**KIRKLEES METROPOLITAN COUNCIL  
INVESTMENT & REGENERATION SERVICE**

**DELEGATED DECISION TO DETERMINE PLANNING APPLICATIONS**

Reference No:	<b>2023/62/90932/E</b>
Site Address:	16, Camroyd Street, Dewsbury, WF13 1PE
Description:	Change of use of land to domestic use, Erection of two storey side extension, two storey rear and single storey front extensions, drop kerb and associated alterations
Recommending Officer:	Jennifer Booth

## **OFFICER REPORT**

Site Plan

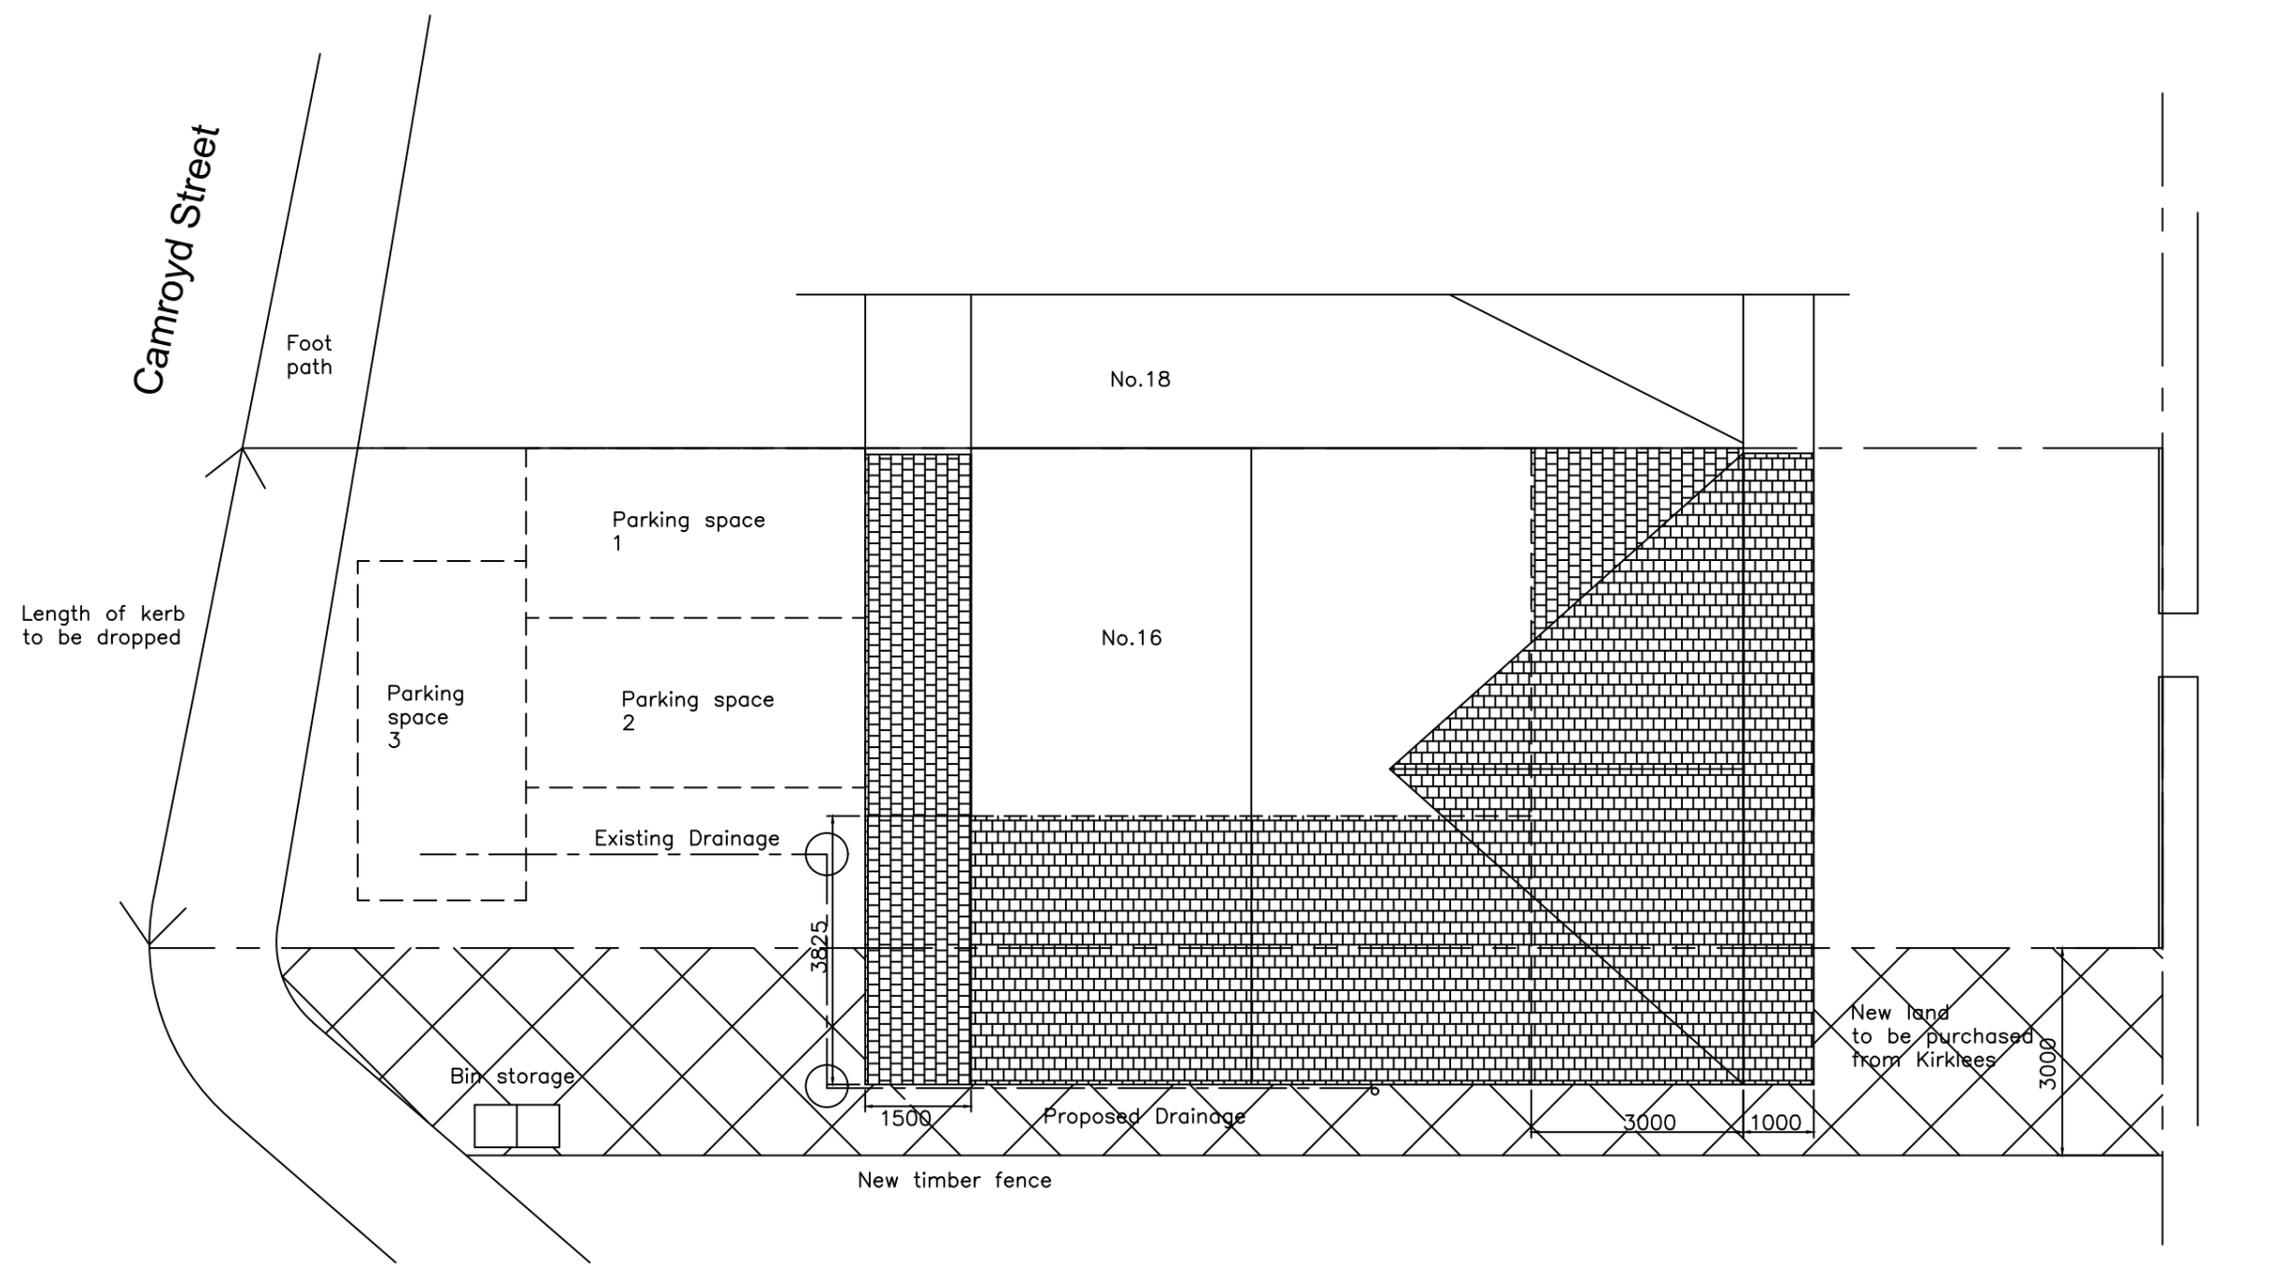
The plans show the provision of parking to the front which would require the removal of the grass. Whilst it is preferable to retain greenery, there are already a number of other properties within this street which have carried out similar works. Furthermore, it is noted that there are some public green areas in the street which would reduce the potential for a harsh sterile impact on the street scene.

The proposals will result in some intensification of the domestic use. The submitted plans show parking being formed to the front of the dwelling for three vehicles which is considered to represent a sufficient provision. Bin storage for the dwelling would not be moved as part of the proposals. As such the scheme would not represent any additional harm in terms of highway safety and as such complies with Policy LP22 of the Kirklees Local Plan along with Key Design Principles 15 & 16 of the House Extension SPD.

Proposed Front Elevation

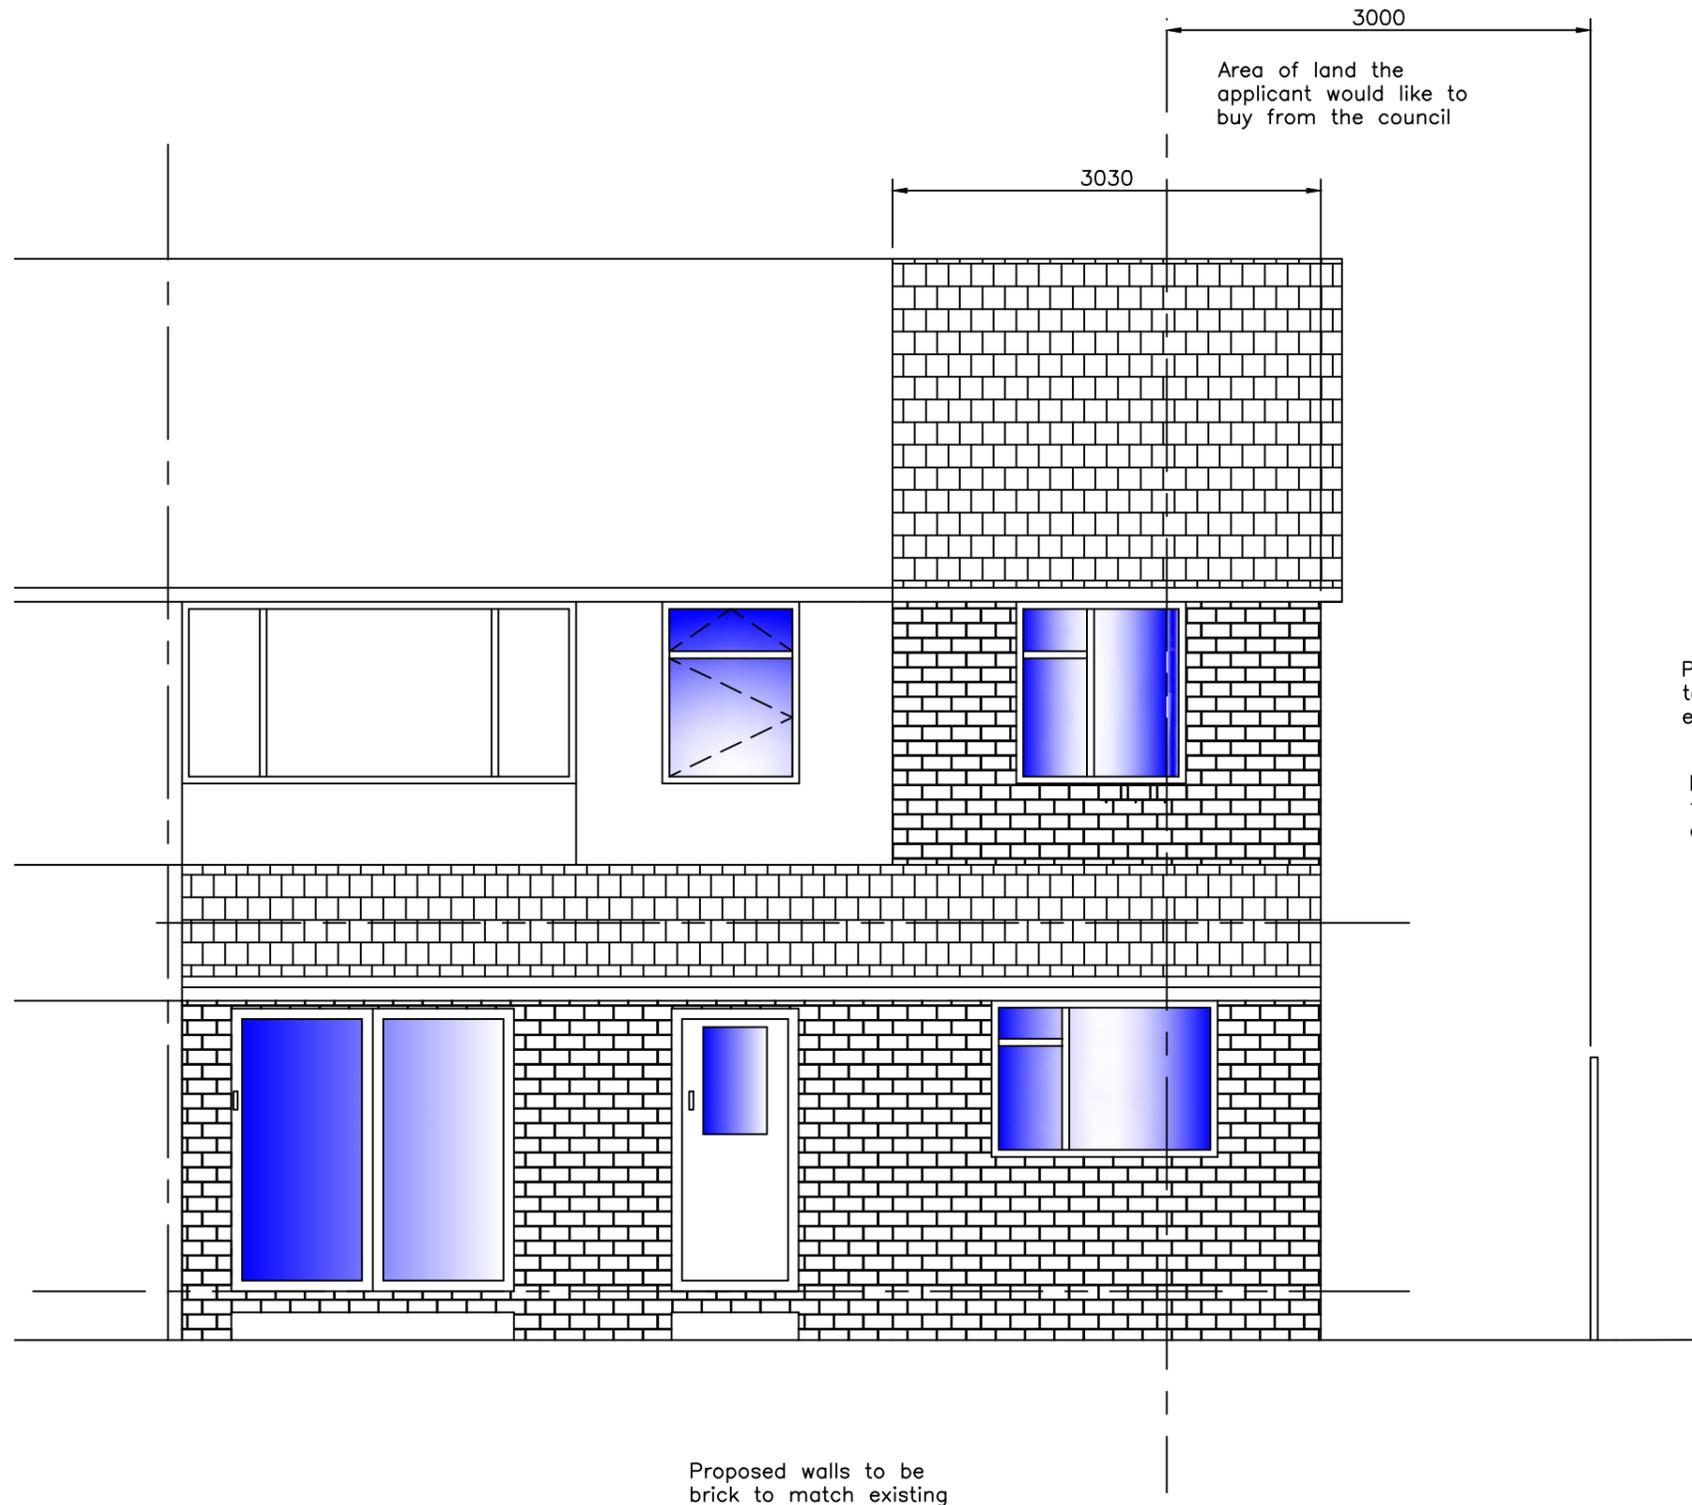
The front extension is proposed to project 1.5m from the original front wall of the dwelling and would extend across the width of the property including to the front of the proposed side extension with a lean to roof form.

The front extension proposed would be prominent within the streetscene. However, there are other such extensions in the area and as such, this would not be out of character with the street. The scale is modest and the materials proposed would match the main house. As such, the front extension is considered to be acceptable in terms of visual amenity.

Proposed First Floor Plan

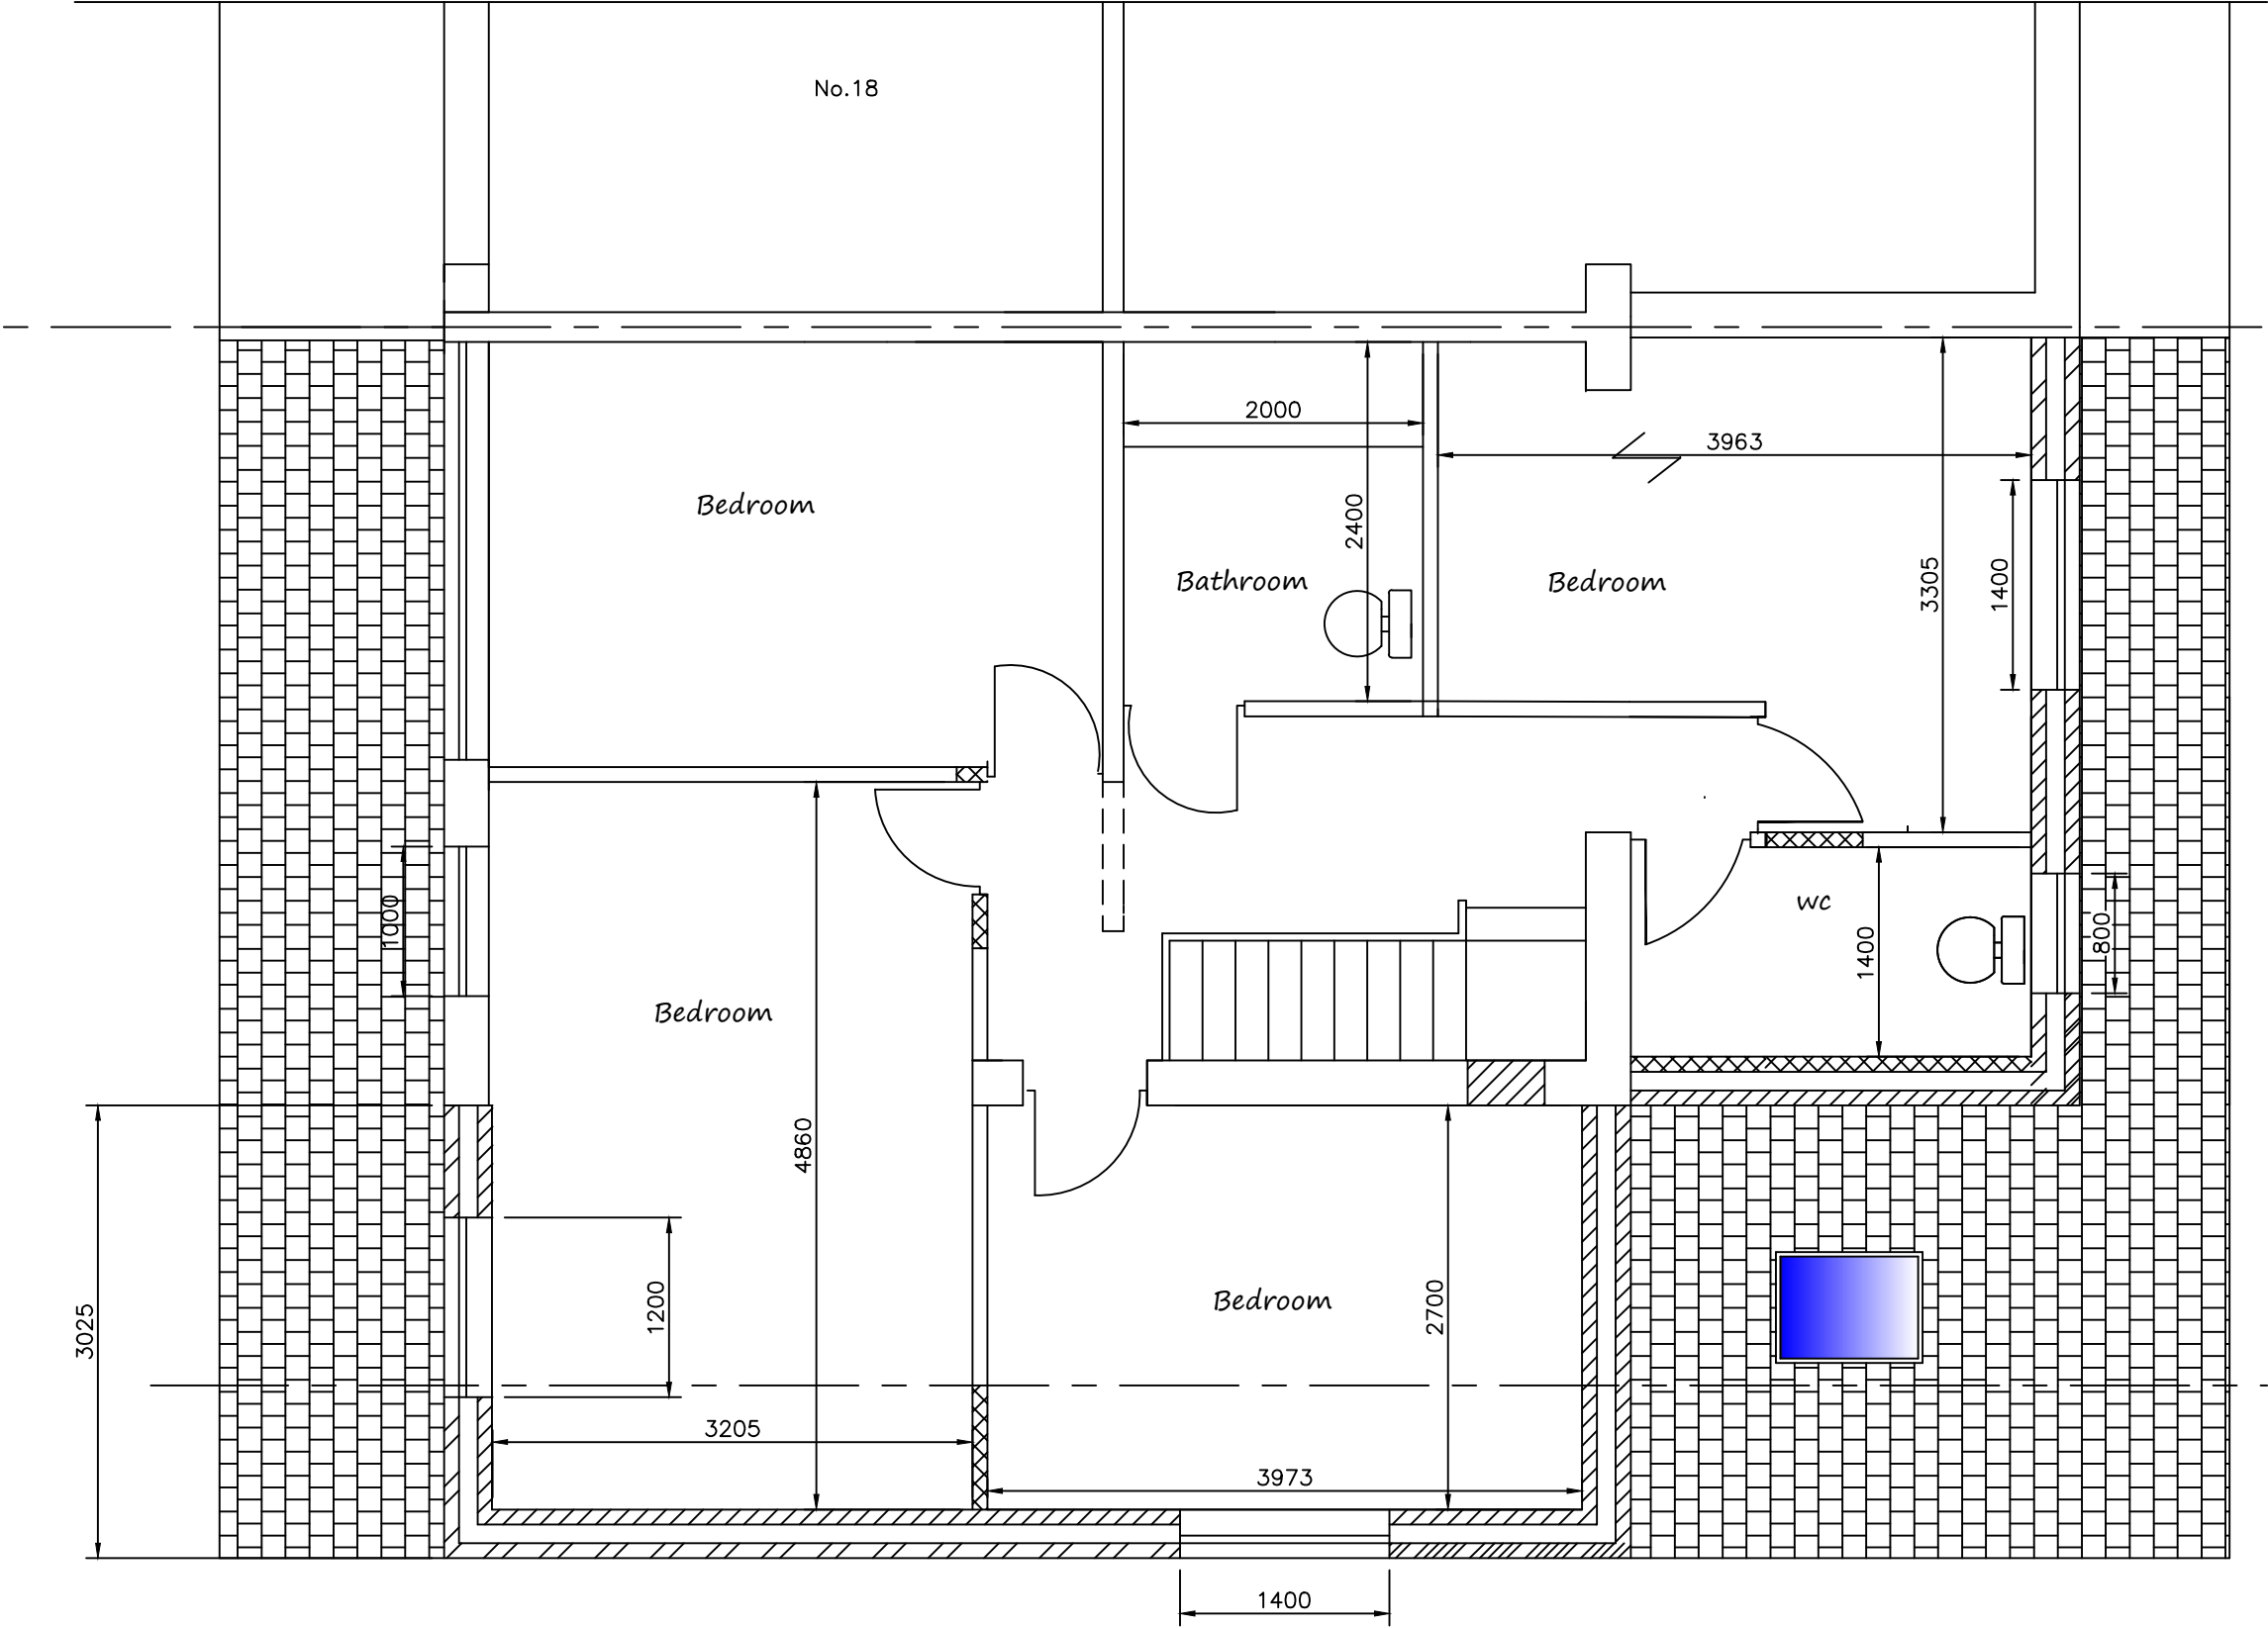
Kirklees Development Management Charter together with the National Planning Policy Framework and the DMPO 2015 encourages negotiation/engagement between Local Planning Authorities and agents/applicants. The initially submitted plans raised concerns in terms of the side and rear extensions. Amended plans have been sought and received to

in reduce the width of the side extension and remove the first floor rear corner. As the alterations reduced the development, the amended plans have not been advertised.
